**Our ref:** AN/2023/135033/01-L01  
**Your ref:** EN070008  
**Date:** 11 January 2023

**Application by Chrysaor Production (UK) Limited for a Development Consent Order (“DCO”) for a 55km underground pipeline for the transport of Carbon Dioxide from the Immingham industrial area to offshore storage – the Viking CCS Pipeline (“the Proposed Development”)**

- 2.2 We have reviewed the Development Consent Order (DCO) application, Environmental Statement (ES) and supporting documents submitted as part of the above-mentioned application, following notification of its acceptance for Examination on 22 November 2023. Our comments below are presented using the document references and ES Chapter headings relevant to our remit.

Figure 1: Map showing locations of SPZ 2 (Blue) and SPZ 3 (Green) transected by the DCO Site Boundary (Red Outline)

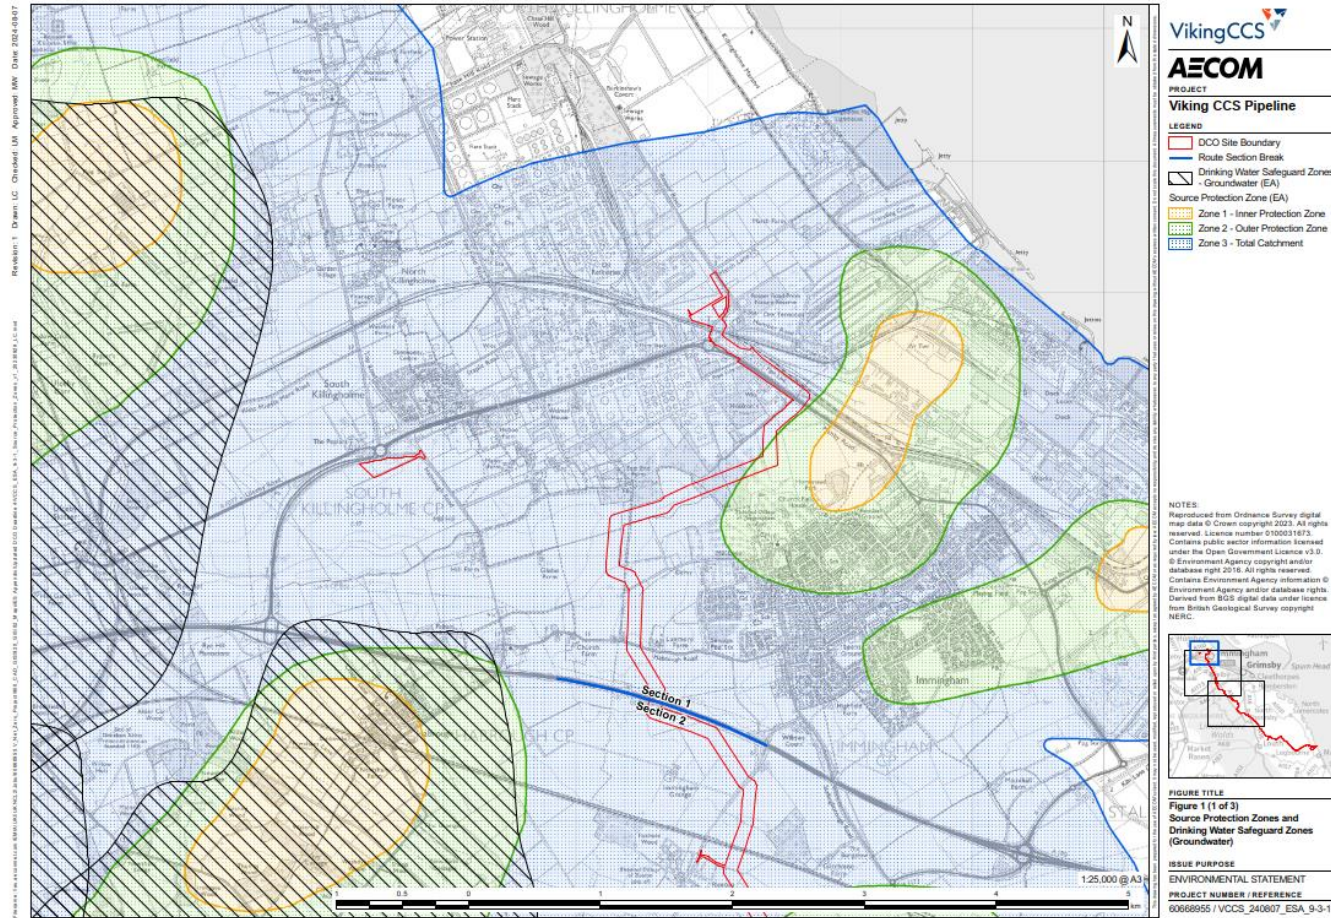
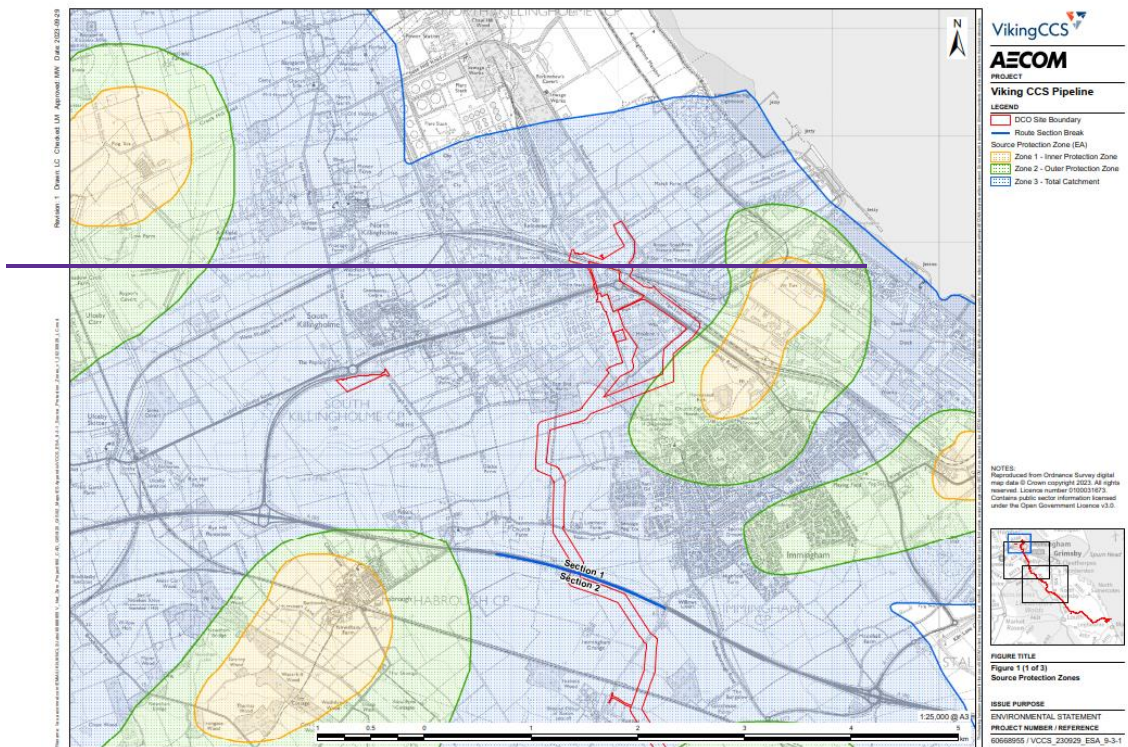
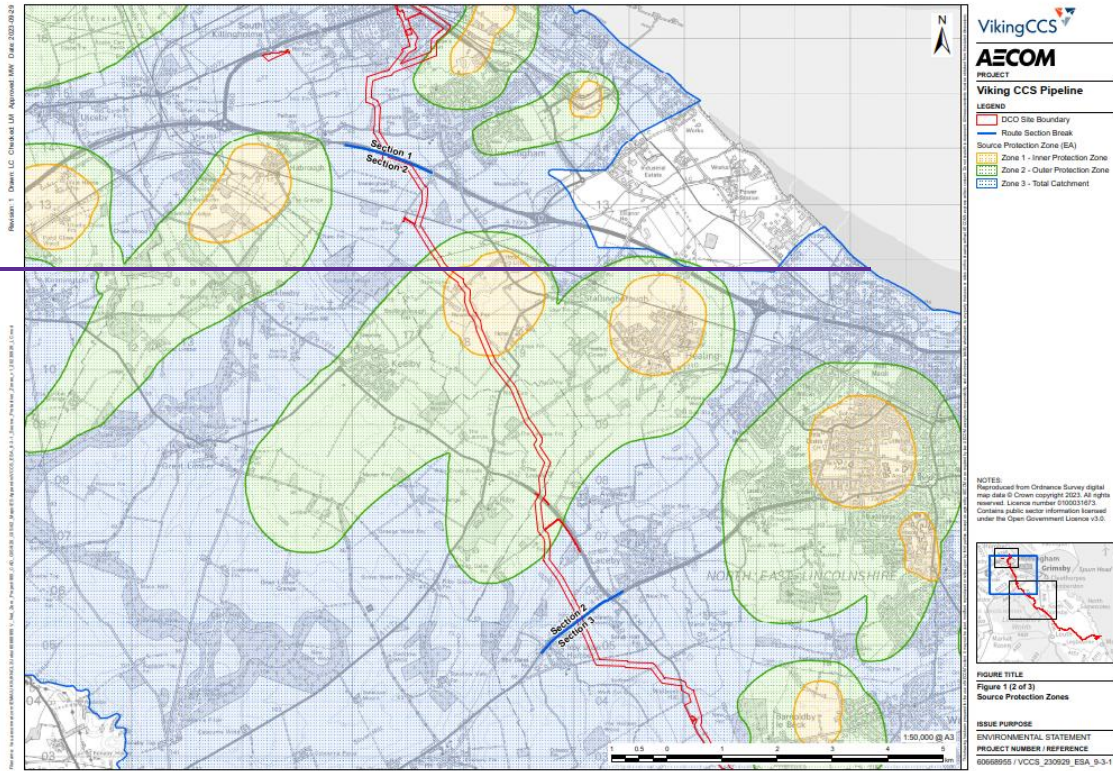
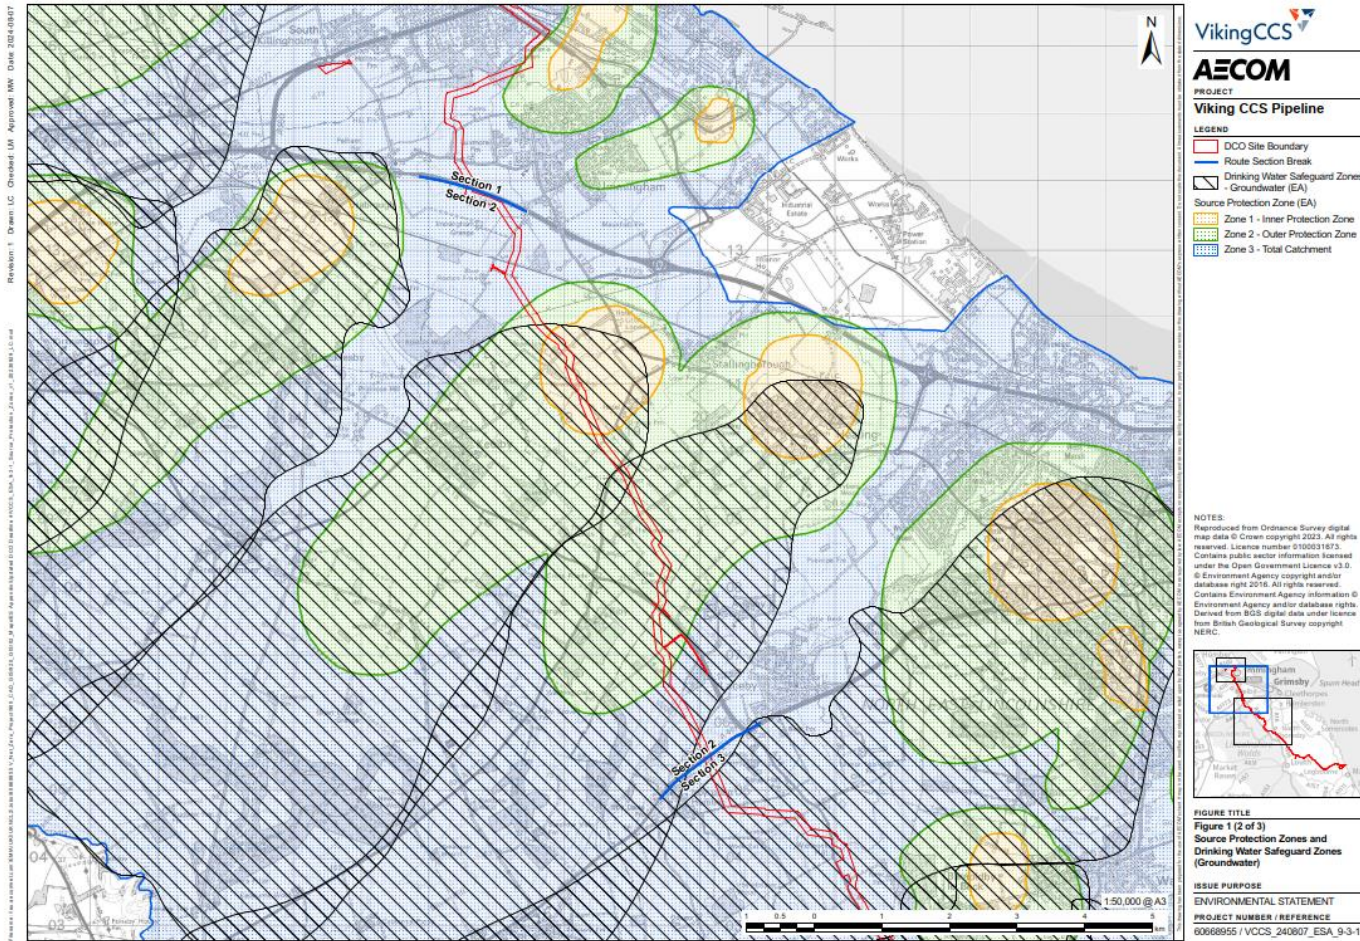
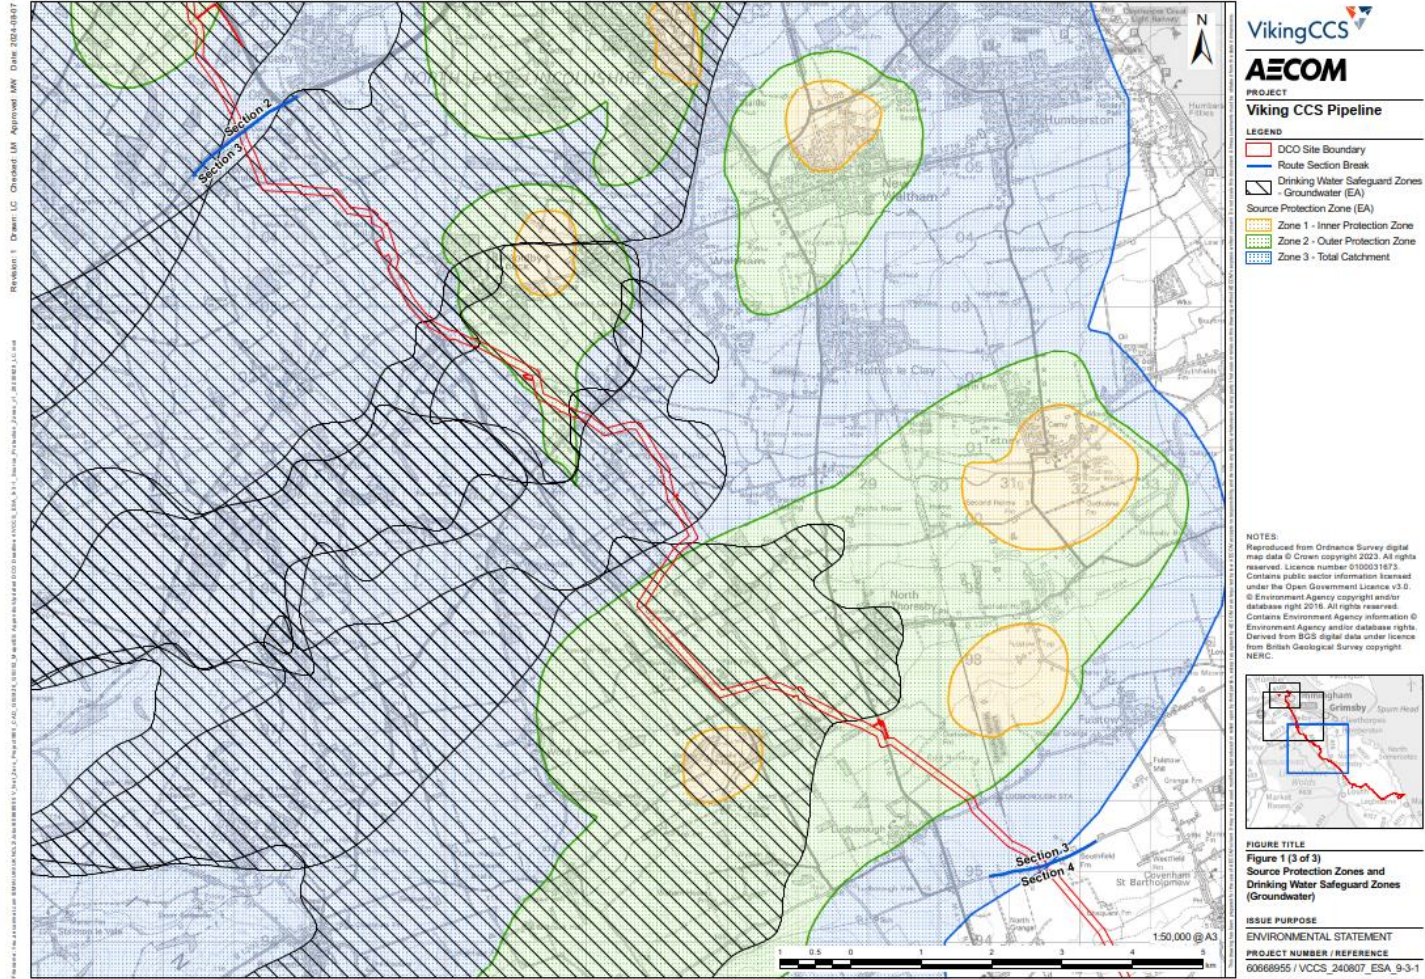
- 6.5 Section 1.3.2 states that groundwater safeguard zones are meant to be designated in Figures 1.2 and 1.3; these are not evident on the diagrams.
- 6.6 We note that in the absence of site-specific ground investigation data at this stage, the Hydrogeological Risk Assessment (HyRA) is considered to be 'preliminary' and will be reviewed and updated based on the findings of future ground investigations. We would like to be consulted on any future updates and believe this is secured through mitigation measure E3 in the draft CEMP (subject to our request to be a specific consultee to the final CEMP discharge).
